Engineers Comments Regarding Surface Water Drainage

Application Reference:	LU/225/26/DOC	Reviewer Reference:	ADC/EXT5/AF
Planning Officer:	Hannah Kersley	Date of Review:	29/09/2026
Site Name:	Land North of Littlehampton Academy Littlehampton		
Application Description:	Approval of details reserved by condition imposed under LU/299/22/PL relating to conditions 18-as built drawings and 19-verification report.		
Assessment Number:	1

Response	Condition 18: Further information required Condition 19: No Comments
-----------------	--

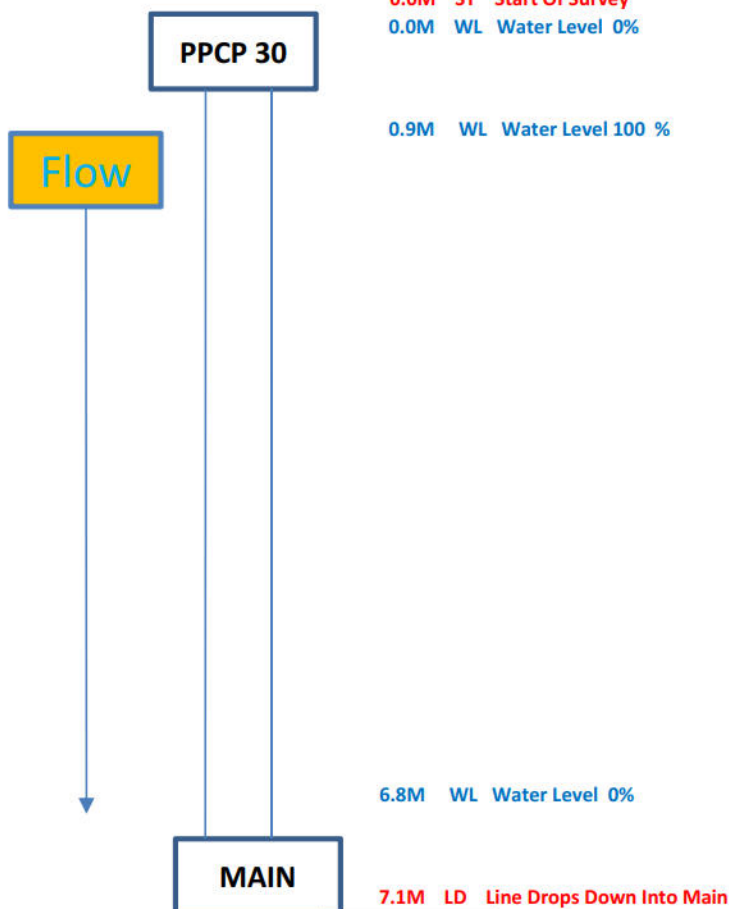
2.	The CCTV survey notes defects on the final page, confirmation that these have been addressed should be provided. A drain reference plan should also be provided with the CCTV survey for clarity.				
Condition Number: 19					
Comment Number					
1.	Note only – Advice to be provided separately on remediation of contaminated ground.
